PLANNING AMENDMENT

Application No. H17/0021/01/A2

Description: Conversion of methodist church
to dwelling

**Conversion of Methodist Church to dwelling at
Station Road, Surfleet, Spalding, Lincs
Reference No: H17/0021/01**

14250 - 11 D

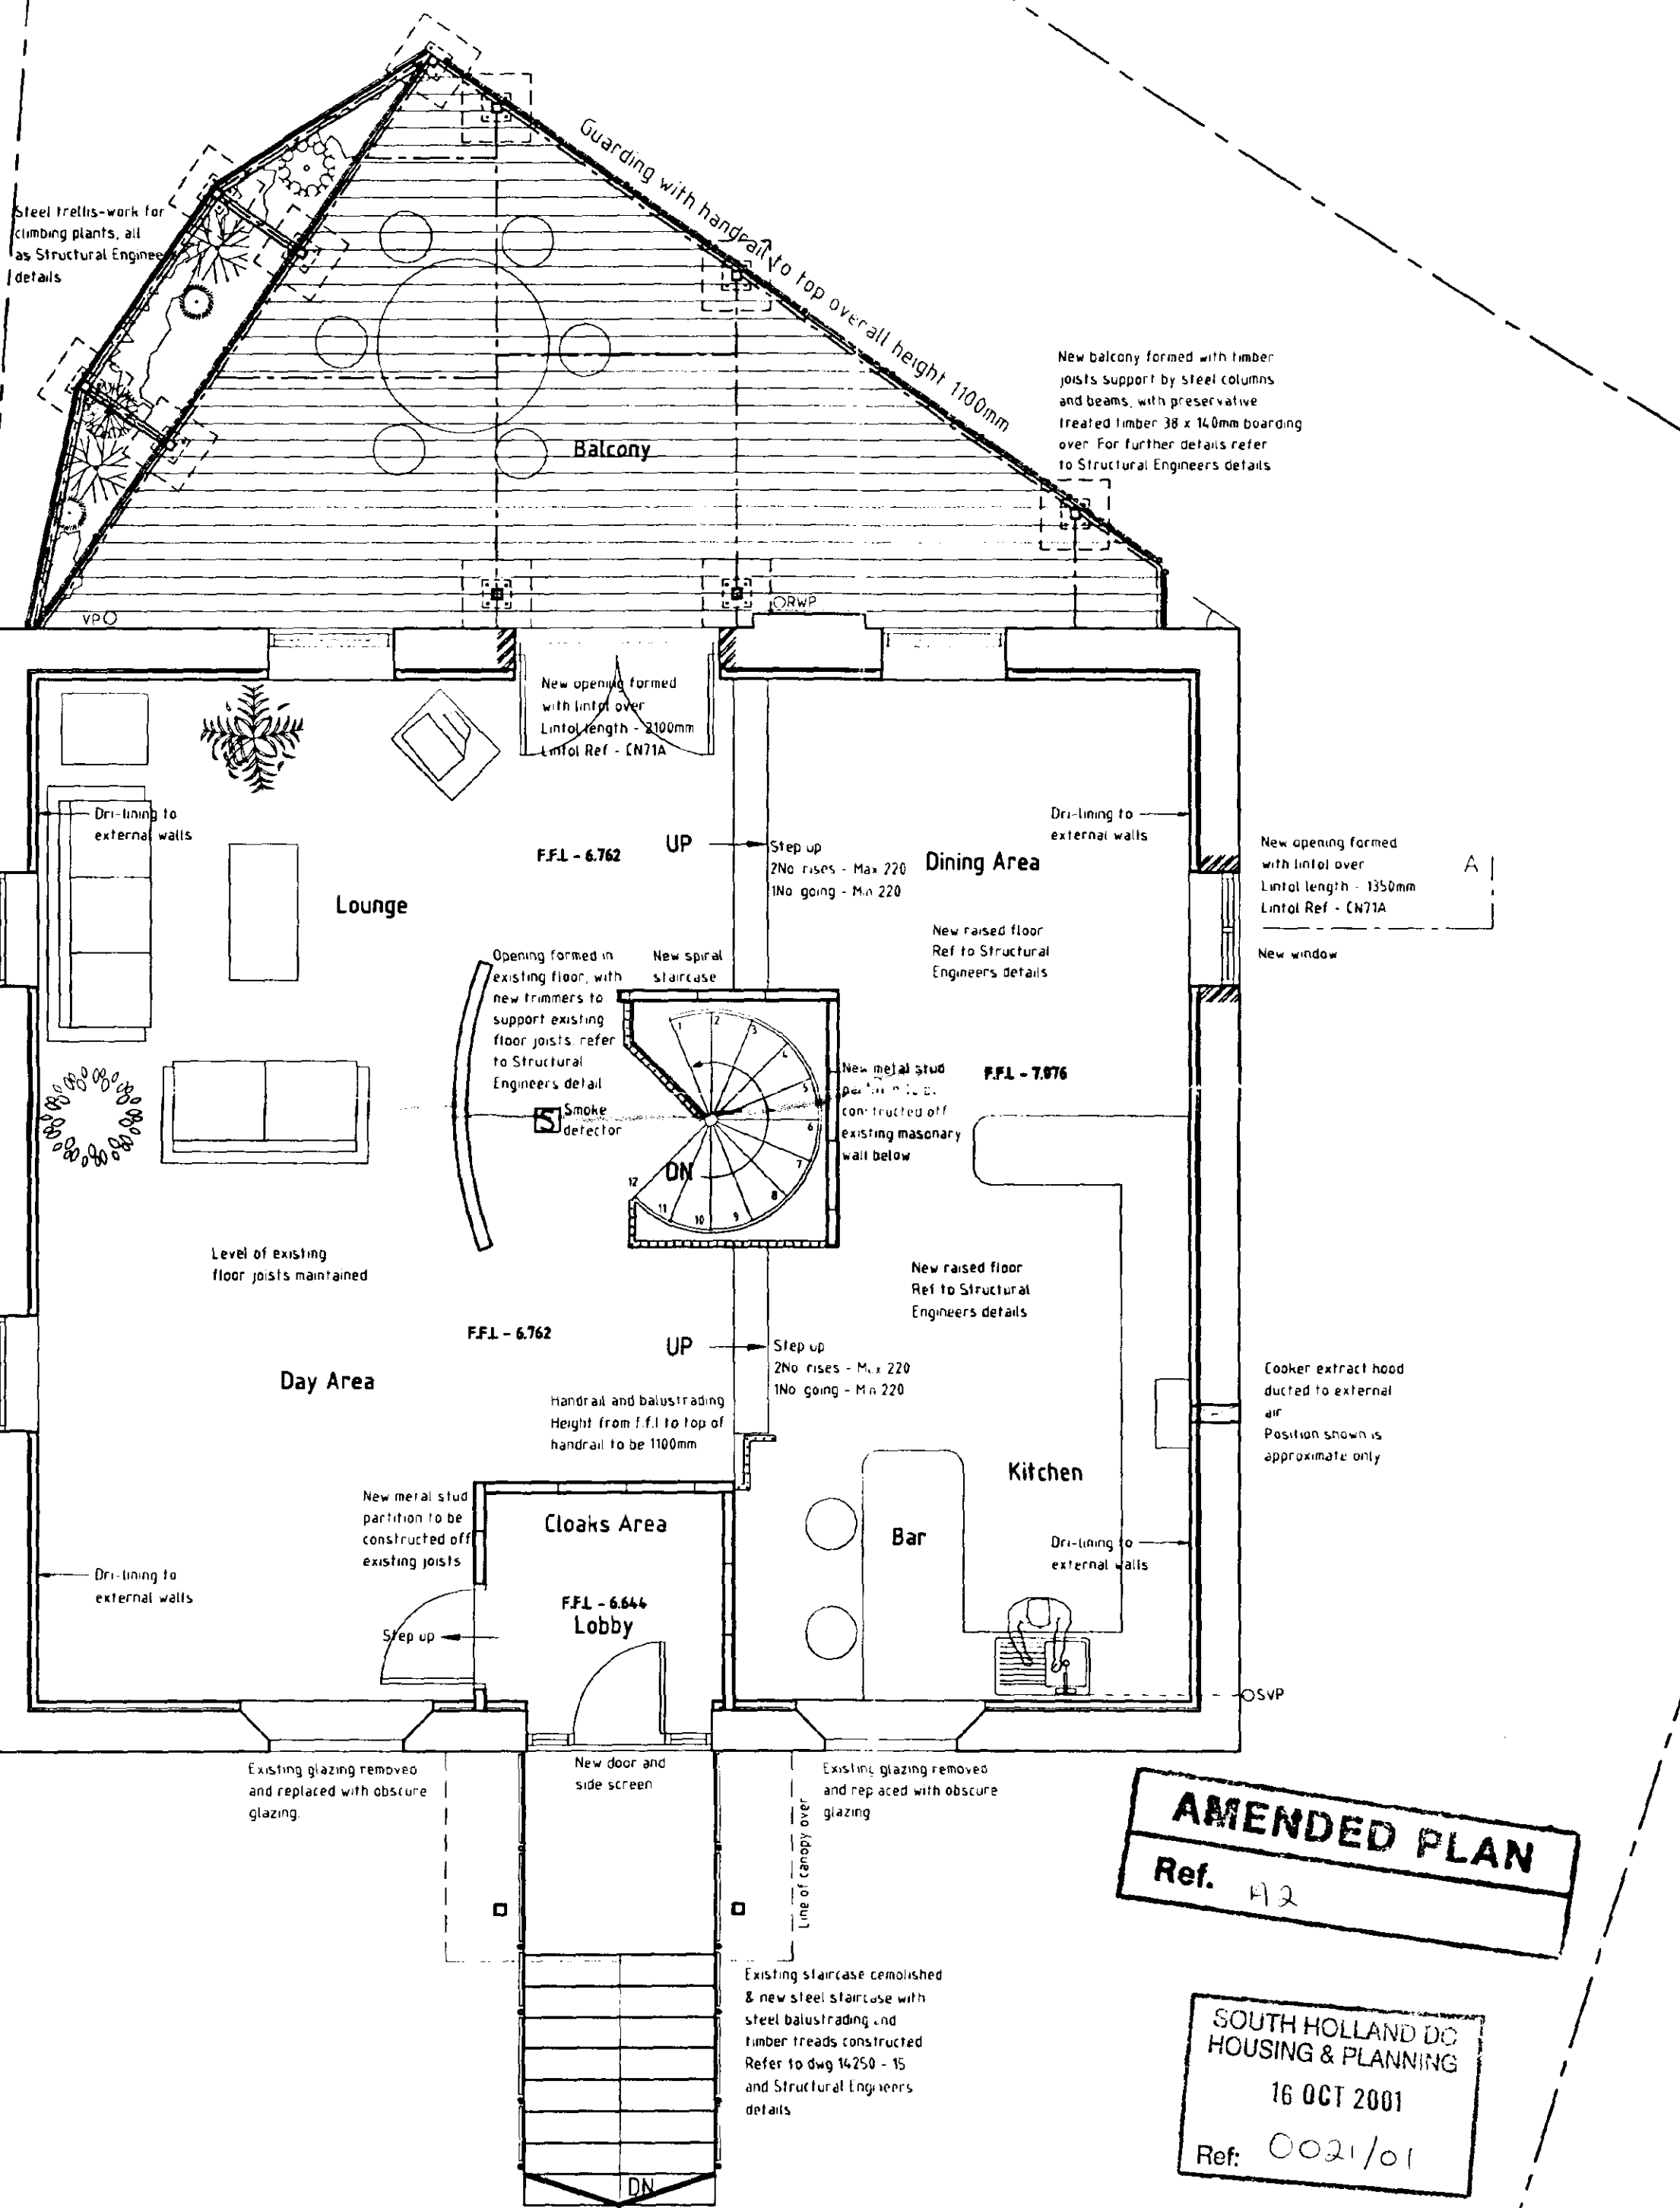
8. The balcony design has been changed and the roof canopy over has been omitted. Trellis and plant screening has been introduced to reduce overlooking of the adjacent property. In this respect we have illustrated our proposals to discharge condition number 5 of the original approval.

- 1) The balcony design, which will be submitted as a Condition Compliance.
- 2) The change to the cill height of the new window to the dining area. Such a change is contrary to Condition 9 and therefore Planning Permission is required. The window as shown on the scheme prepared by G.R. Merchant on drawing number 138/00/02, can be installed in accordance with the Planning Permission.

DRAWING REFERENCE NUMBER / REVISION : 14250 - 10 D

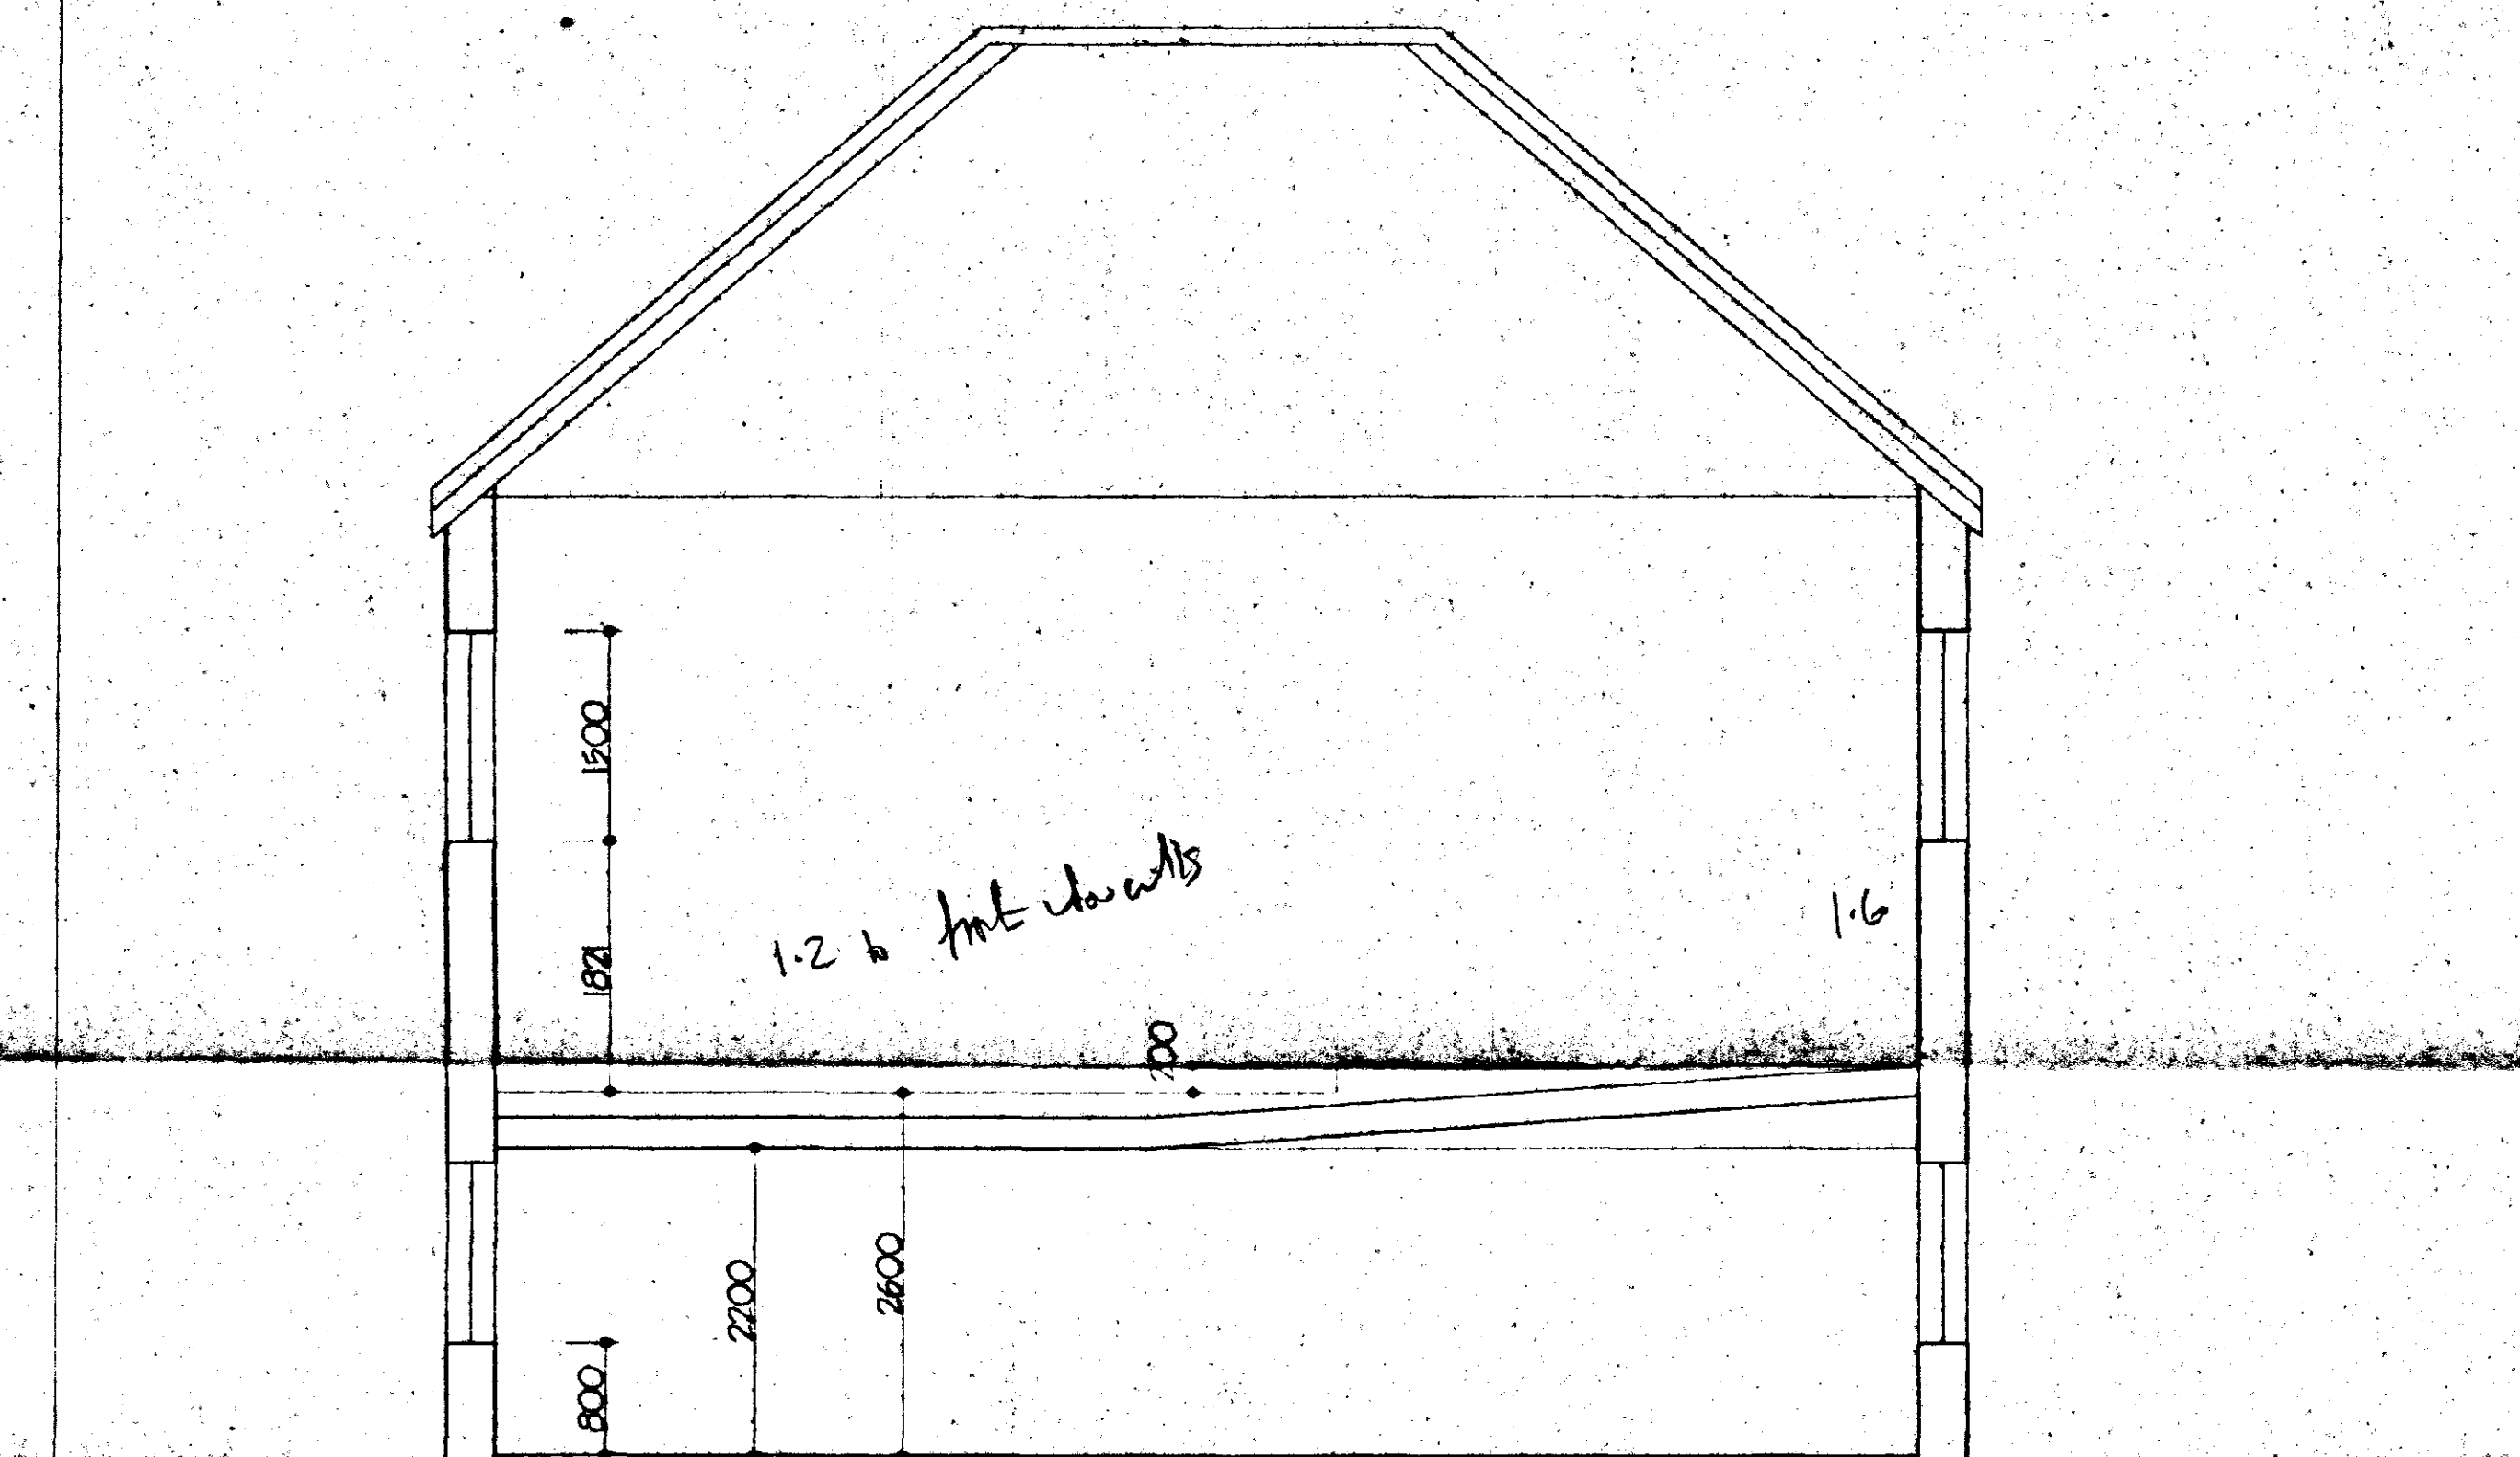
1. *OK* At ground floor level on the front elevation the window directly beneath the new external staircase has been amended from glass block screen to window.
2. *OK* At ground floor level the existing external door to the bathroom is now to be retained not replaced by a window as originally proposed.
3. *OK* At ground floor level, the proposals for new rear doors to the master bedroom have been changed from a pair of doors to a single door.
4. *OK* Minor amendments (as a result of technical development) have been made to the proposed external entrance staircase.
5. *OK* Minor amendments (as a result of technical development) have been made to the front door design.
6. *OK* The first floor balcony access doors have been changed to open in.
7. *OK* The eill height of the proposed new window to the dining room has been reduced.

9. ^{OK} The proposed garage has now been omitted.

- Ground floor front window, behind staircase
- Return ^{external} doorway to bathroom
- Change external rear doorway to bedroom to a single door
- alterations to front external staircase
- Change to flat door design
- Change to rear doors to balcony to open in.
- Omit garage
